Appeal Decision

Appeal Ref: APP/R5510/W/22/3290650

11 Warwick Road, West Drayton UB7 9BT

SES-000-1-ESE

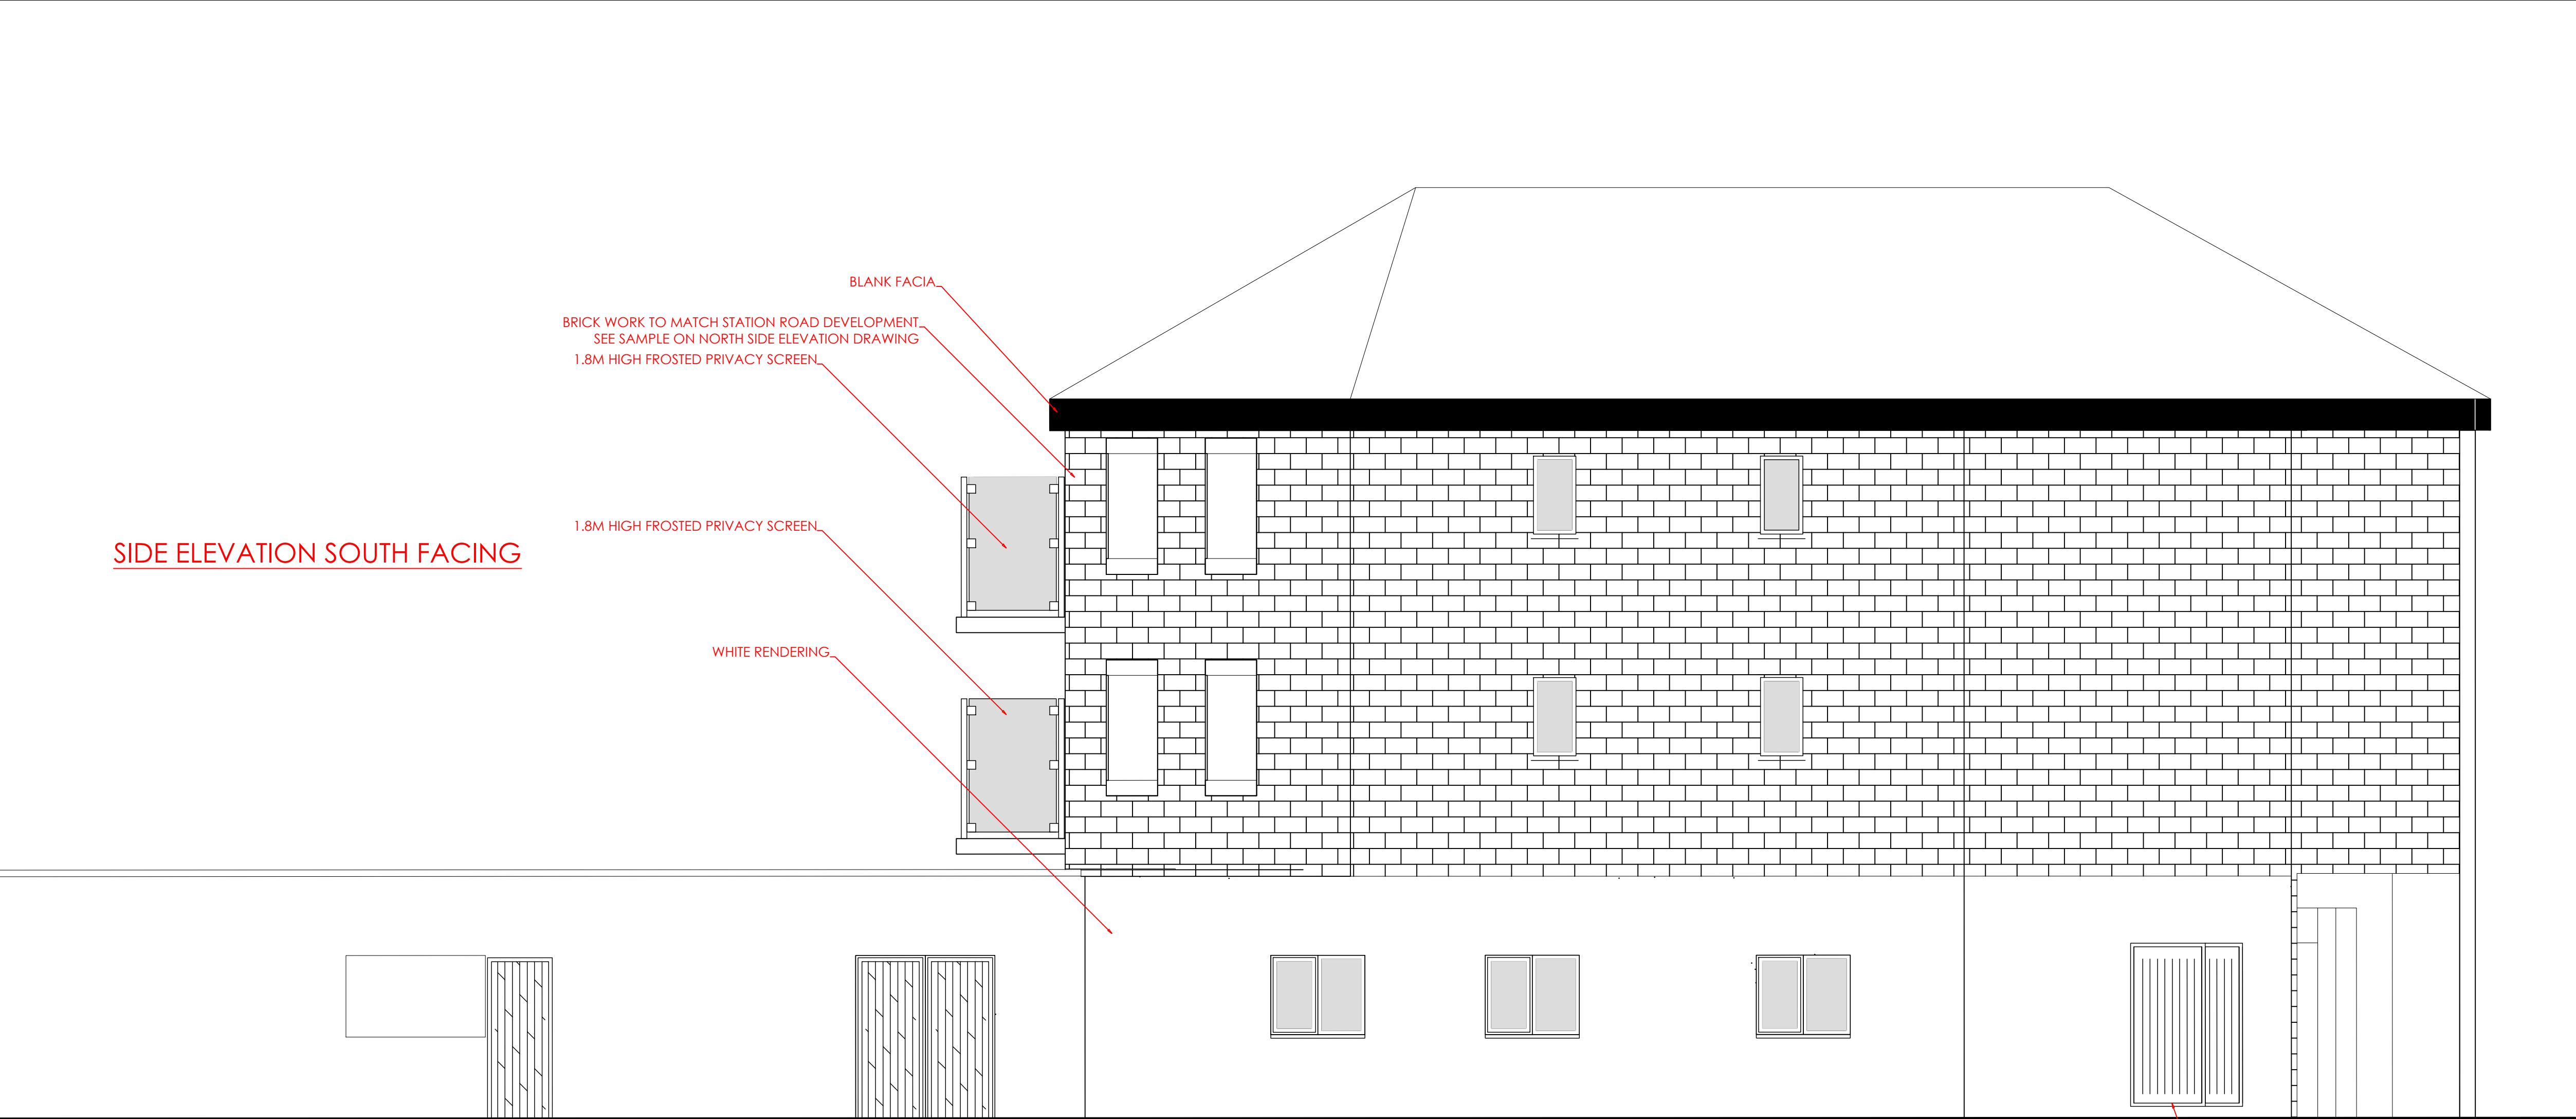
2. In submitting the appeal, the appellant has sought to respond to the Council's concern that the submitted plans do not accurately reflect the scale of the adjacent Pullman Court building. To this end, revised elevations¹ have been submitted which purport to show the 'as built' heights of that building relative to the appeal proposal. The Council have not challenged the appellant in this respect, and I have therefore considered the proposal on this basis.

10. Whilst the existing building already stands forward of this line modestly it does so modestly, its single storey scale not dissimilar to that of the single storey bay windows of the adjacent terrace. It is unobtrusive. The proposed two storey extension would not be. Whilst I have noted the appellant's efforts to respond to the previous Inspector's comments regarding the form of the development and its blank south elevation, I am not persuaded as to their success.

11. The additional scale, height and bulk of the extended upper floors would be disruptive and incongruous within the street when viewed from the south, being altogether more angular and cumbersome than the softer (and smaller) bays. The incorporation of brickwork at upper floor with render below would help break up the elevation to a limited degree, but the result would

nevertheless still result in an intrusive and awkward juxtaposition with No. 9 and its terraced block.

12. A step change between the lower level of the terraced houses and the larger scale of Pullman Court beyond would not, in principle, be harmful. The site is, after all, recognised as being at a point of transition between buildings of differing styles and scales. However, the appellant has acknowledged that the originally submitted plans downplayed the scale of the proposal relative to Pullman Court by overstating the latter's overall height. Updated plans purport to correct this.

SES-000-1-NWE

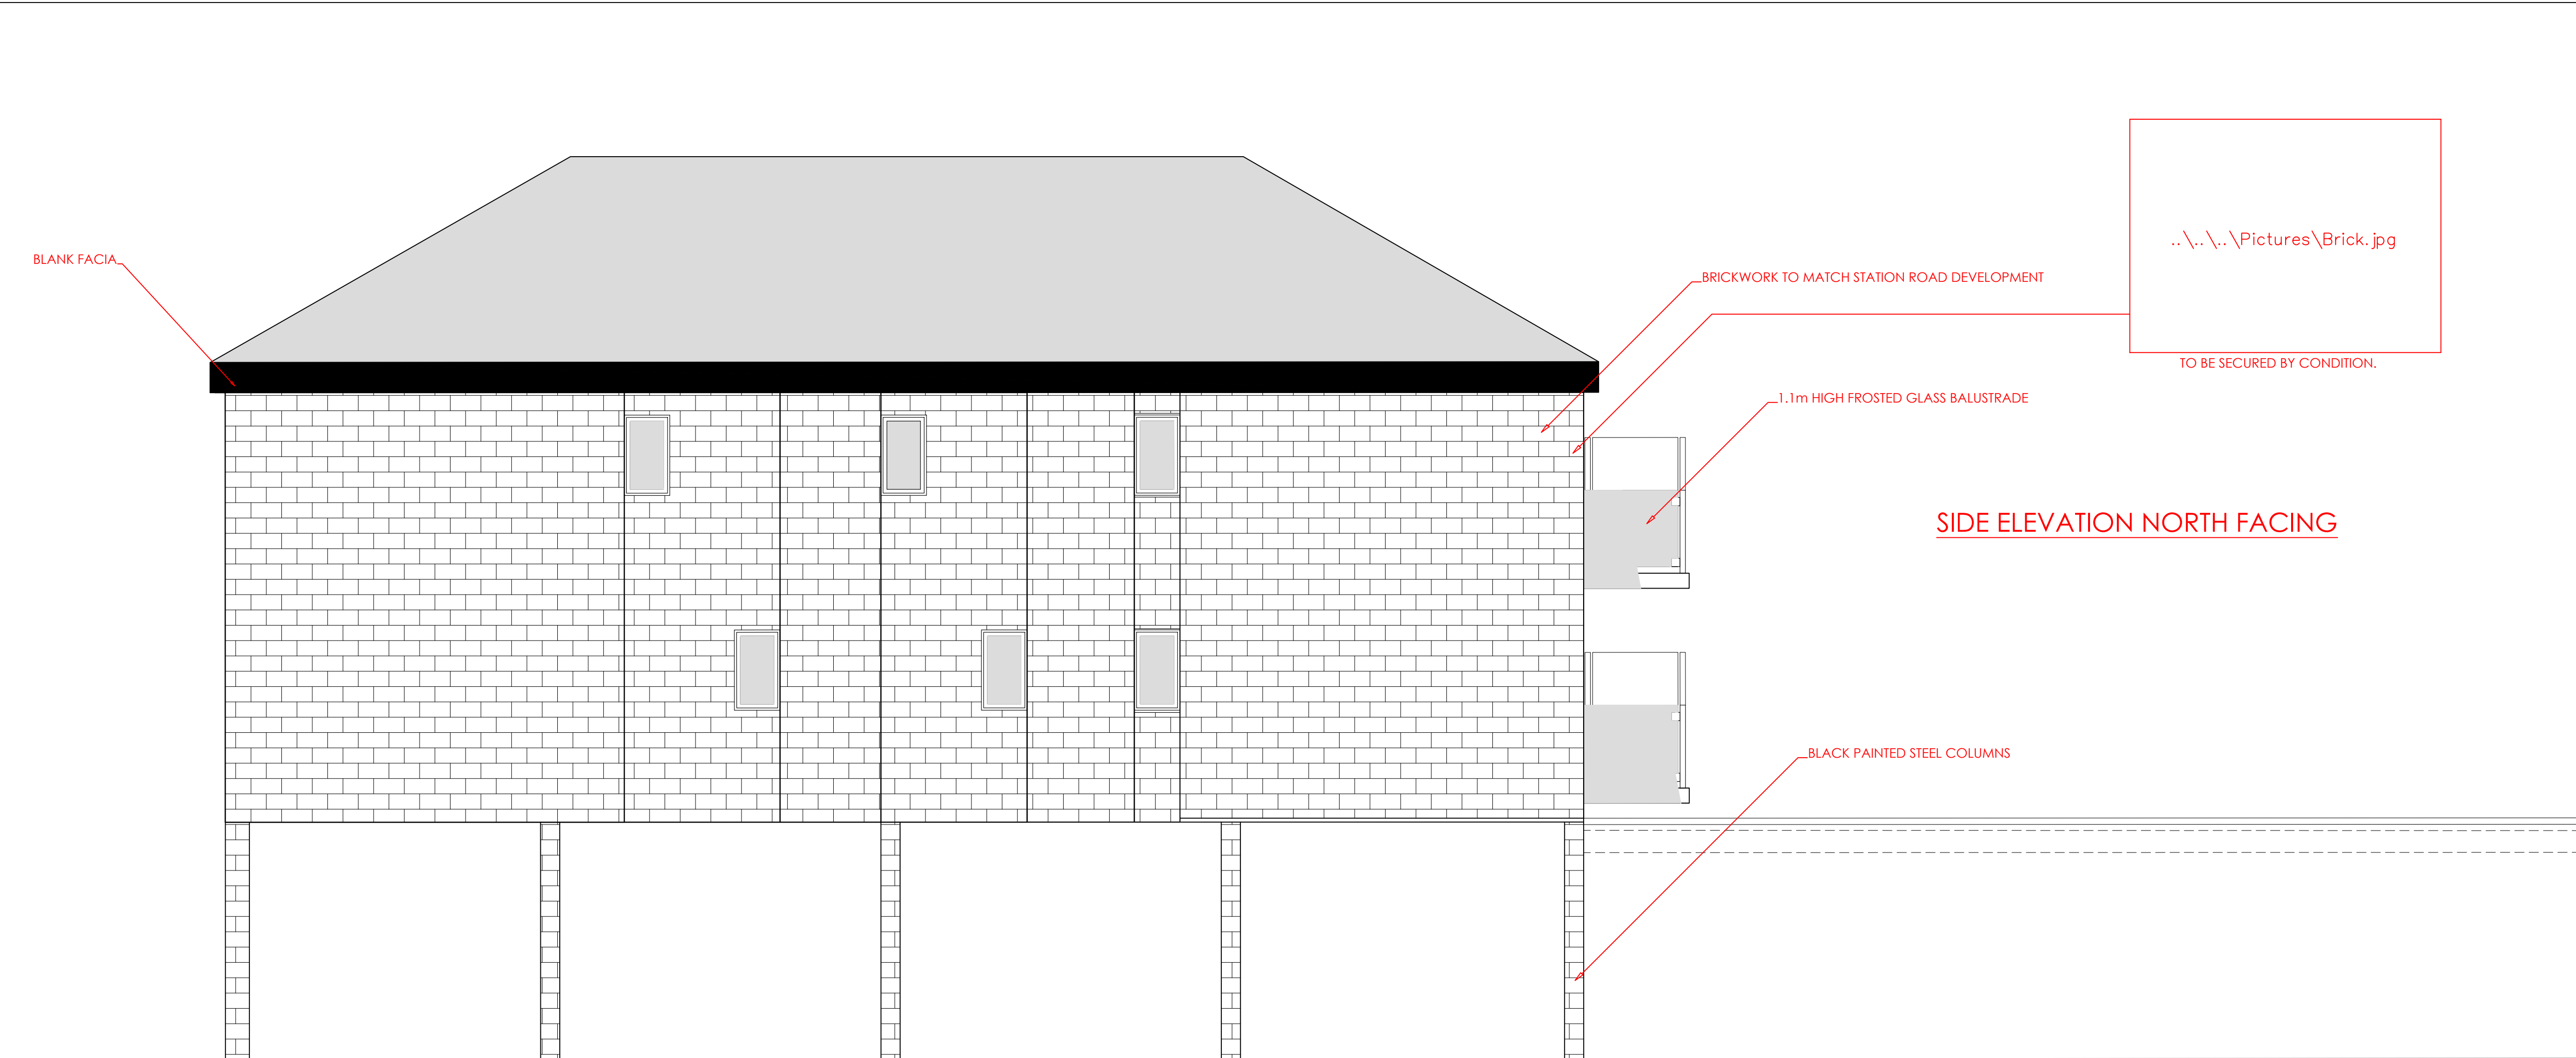
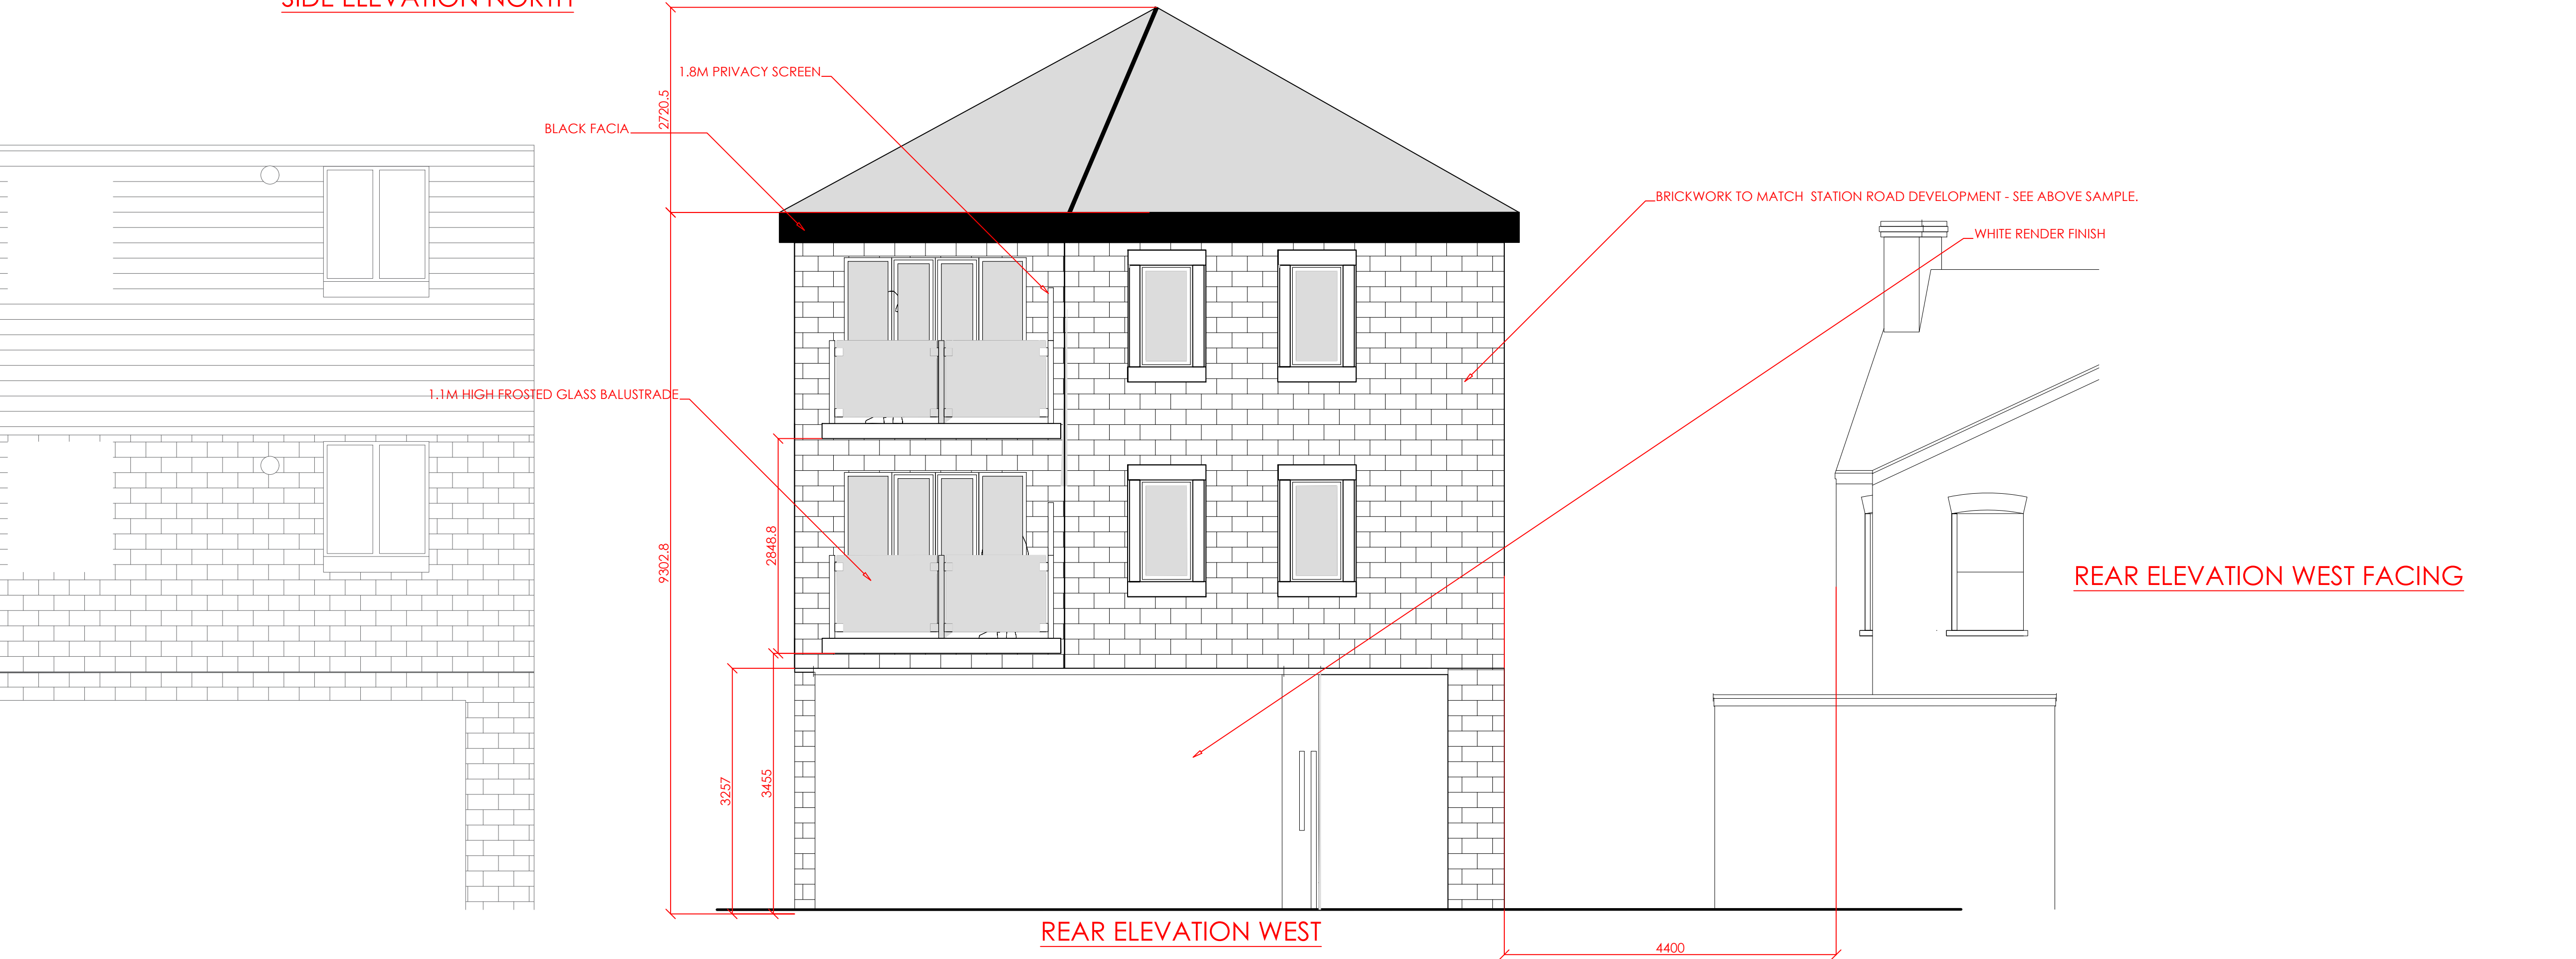
13. Nevertheless, because of the prominence that the building would gain within the Warwick Road environment as a consequence of the extension, its scale, height and bulk would also be incongruous as a bridge between the buildings of differing scale on either side of it. This would be seen both in views from the south along the face of the terrace, but also from the east where the building would present both an abrupt step change from the smaller terrace to the south, as well as being uncomfortably taller than Pullman Court to the east. Whilst the three storey Warwick Road frontage of Kitchener House would provide a degree of foreground scale and context in these views, the awkward mismatch in scale in relation to its neighbours would compound the extended buildings incongruous appearance and discordant effect upon the character and appearance of the surrounding area.
